Application No: EP/7/21/HH
Site Address: Little Dormers 23 Upper Drive East Preston BN16 1QN
Description of works: New bay/porch skirt roof to front elevation & single storey front extension to provide additional garaging.

Thank you for your internet representation made on 4th March 2021 which has been recorded as an objection with the comments as follows:

I am commenting on behalf of the East Preston and Kingston Preservation Society.

Ground Floor Plan
1:50

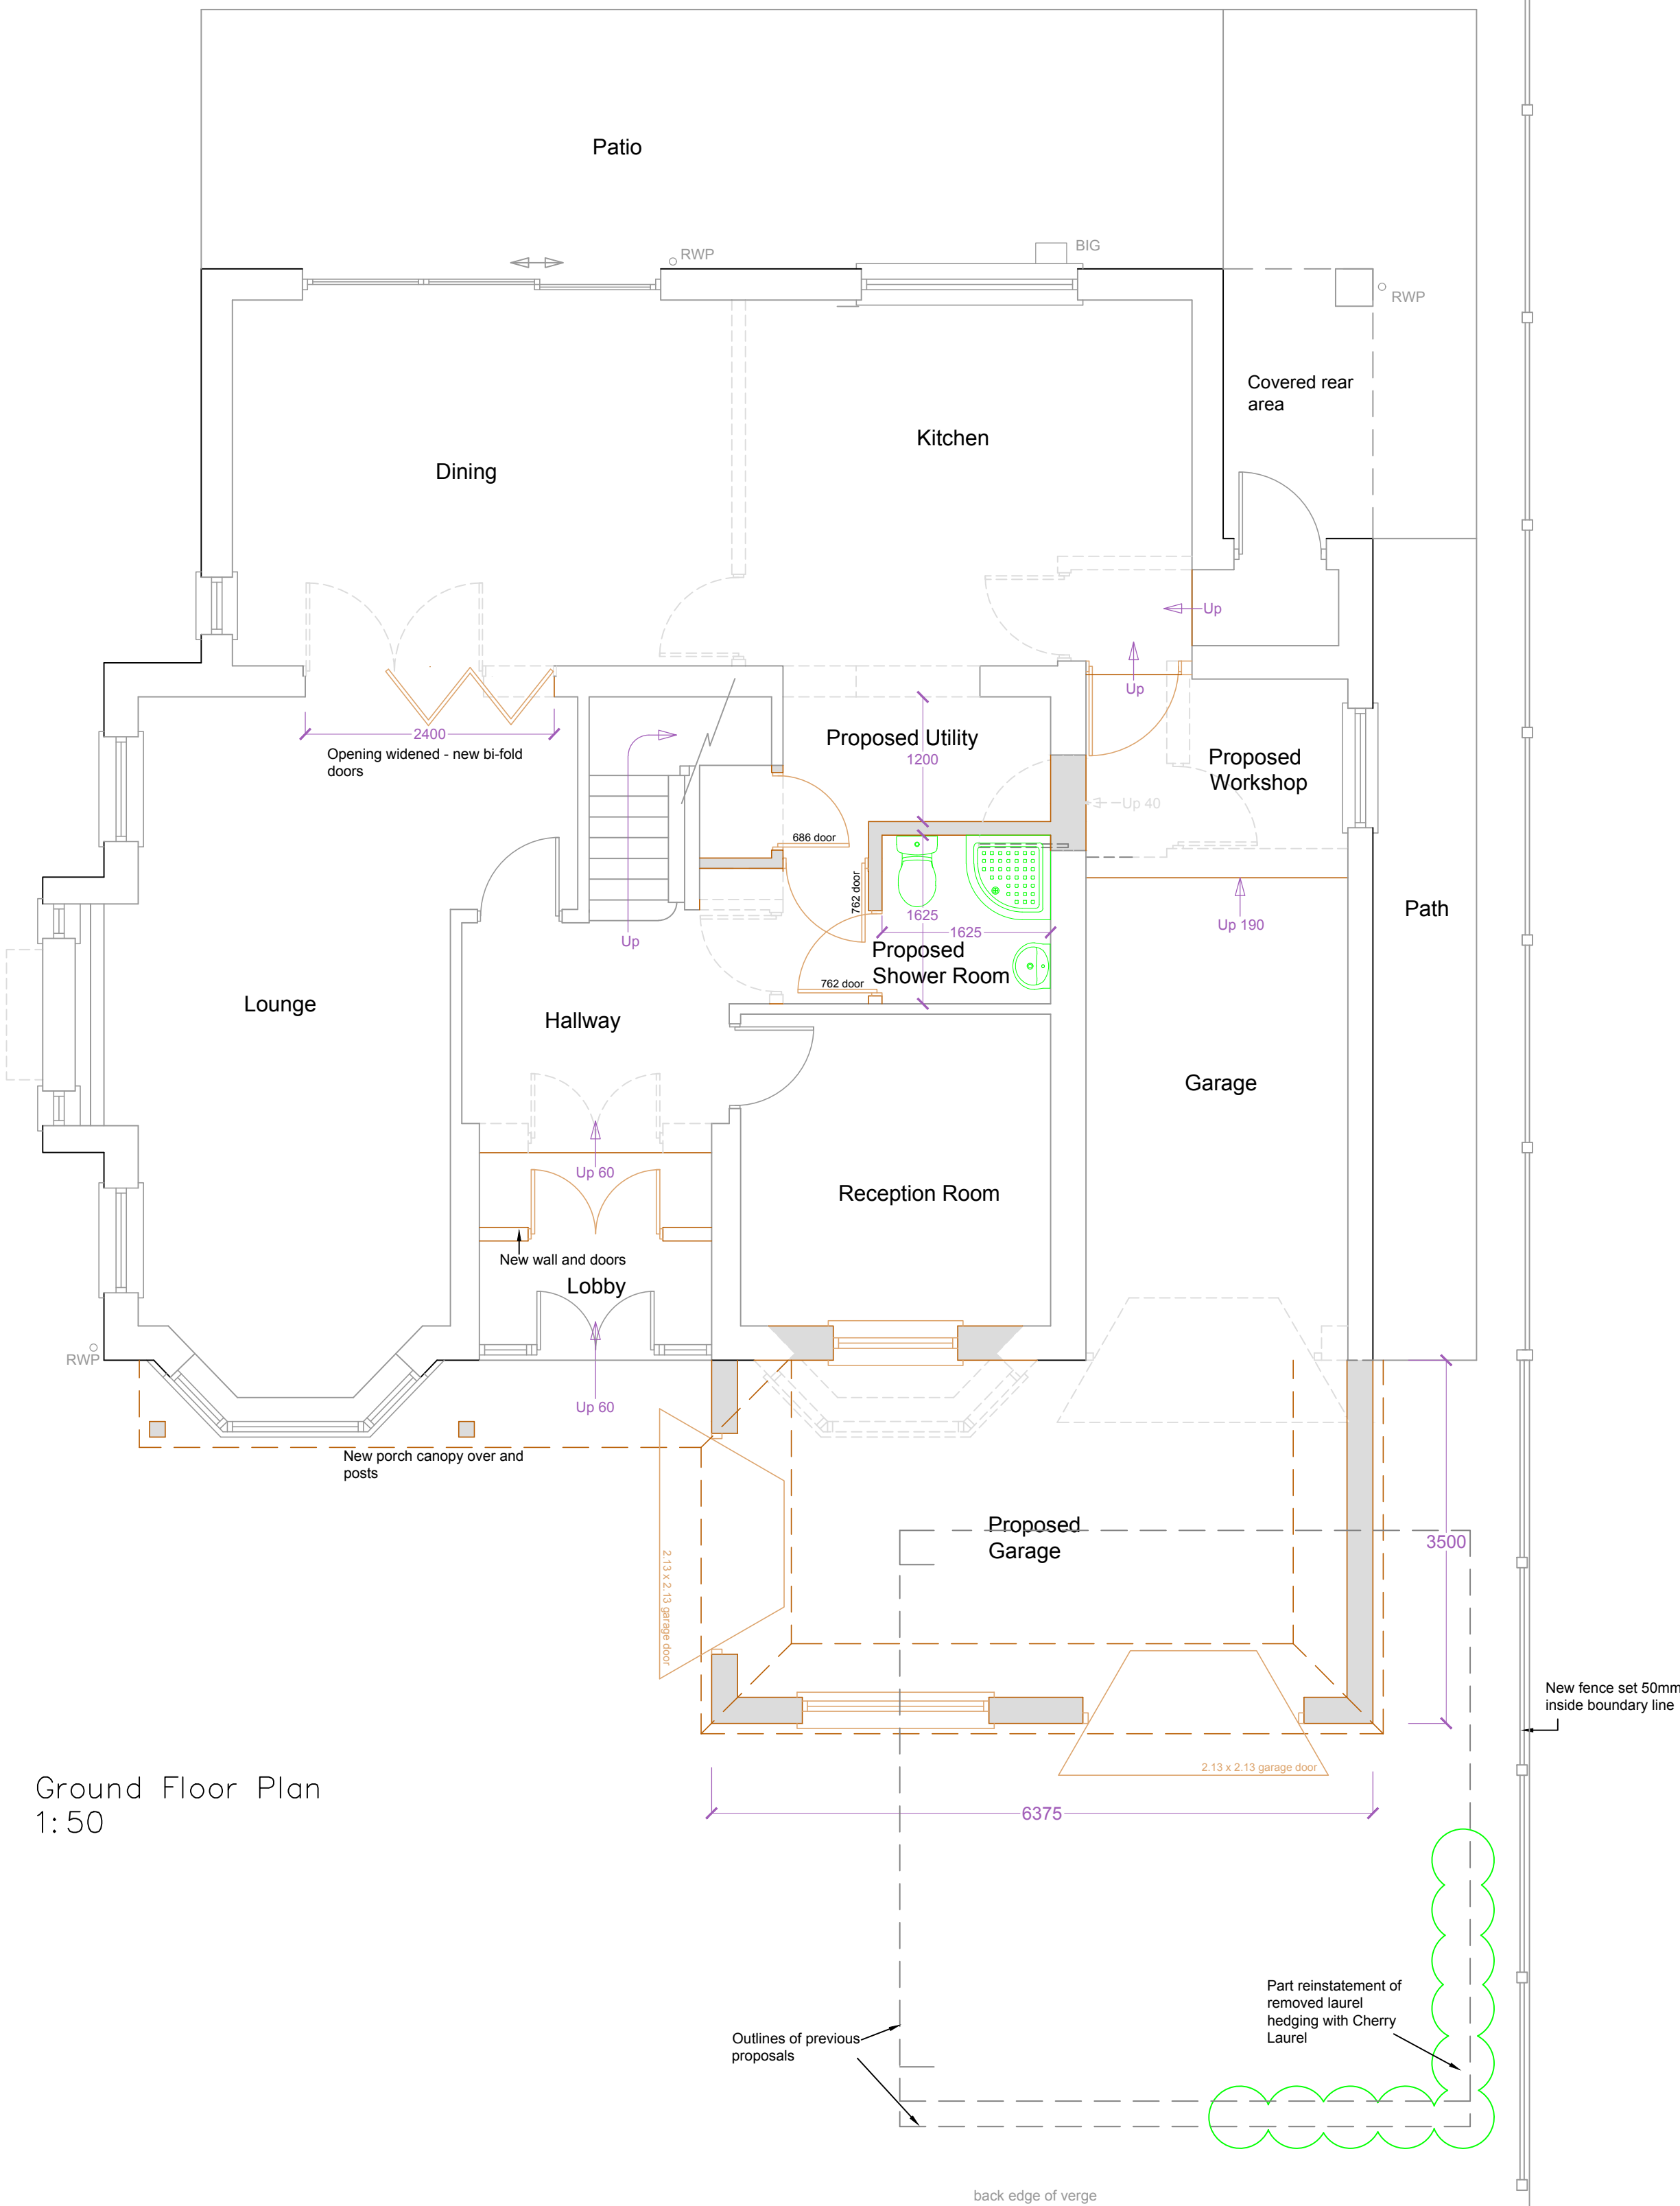
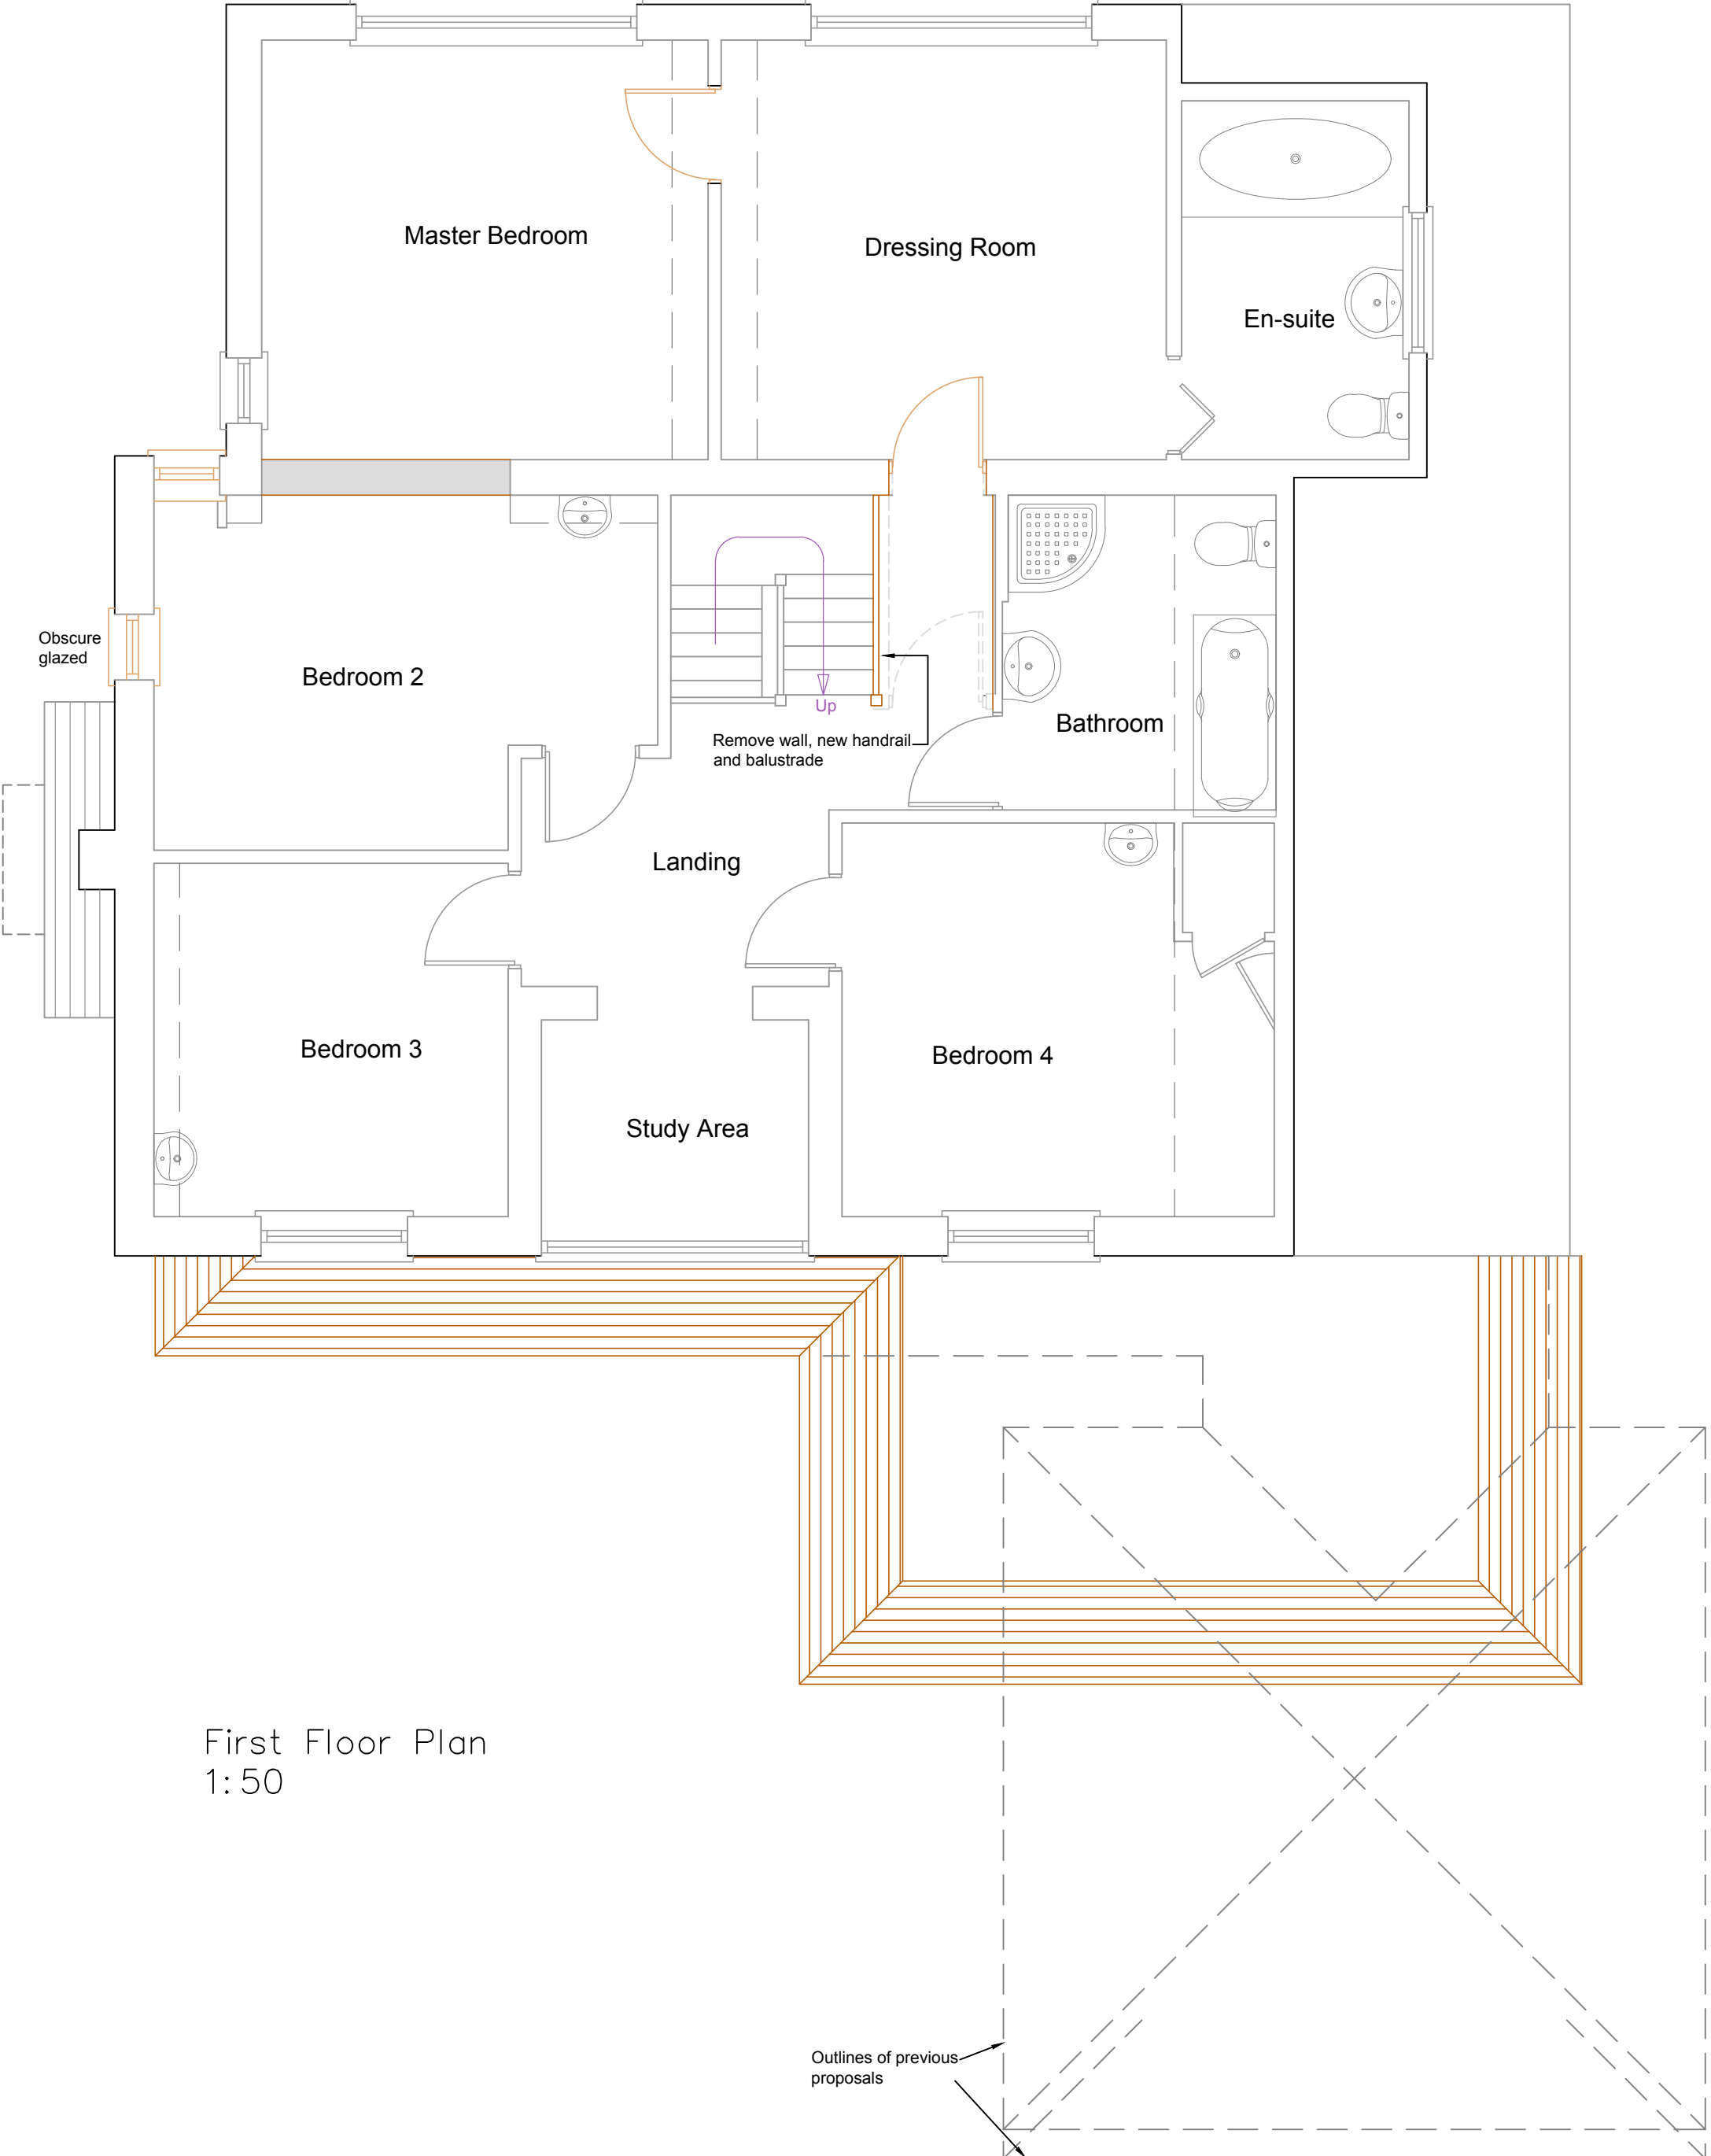
This proposal to build a substantial extension on the front of a house, and add a skirt roof along its facade, would create an extension which could not sympathetically relate to and be visually integrated with, or subservient to, the main structure of the house. Its position, in front of the main structure, and on its street face, would make it the dominant feature of the appearance of the house from the road. Little Dormers is an attractive example of a 1920s Arts and Crafts style of house, with a half timbered facade, and the extension would destroy the symmetry that the house now possesses. The proposed extension would therefore contravene Policy D DM4 of the Arun Local Plan.

The extension would also be built across the window of one living room of the house. Paragraph 13.4.3 of the Local Plan states that extensions should be designed to ensure adequate natural light within the building. This proposal fails to meet this condition.
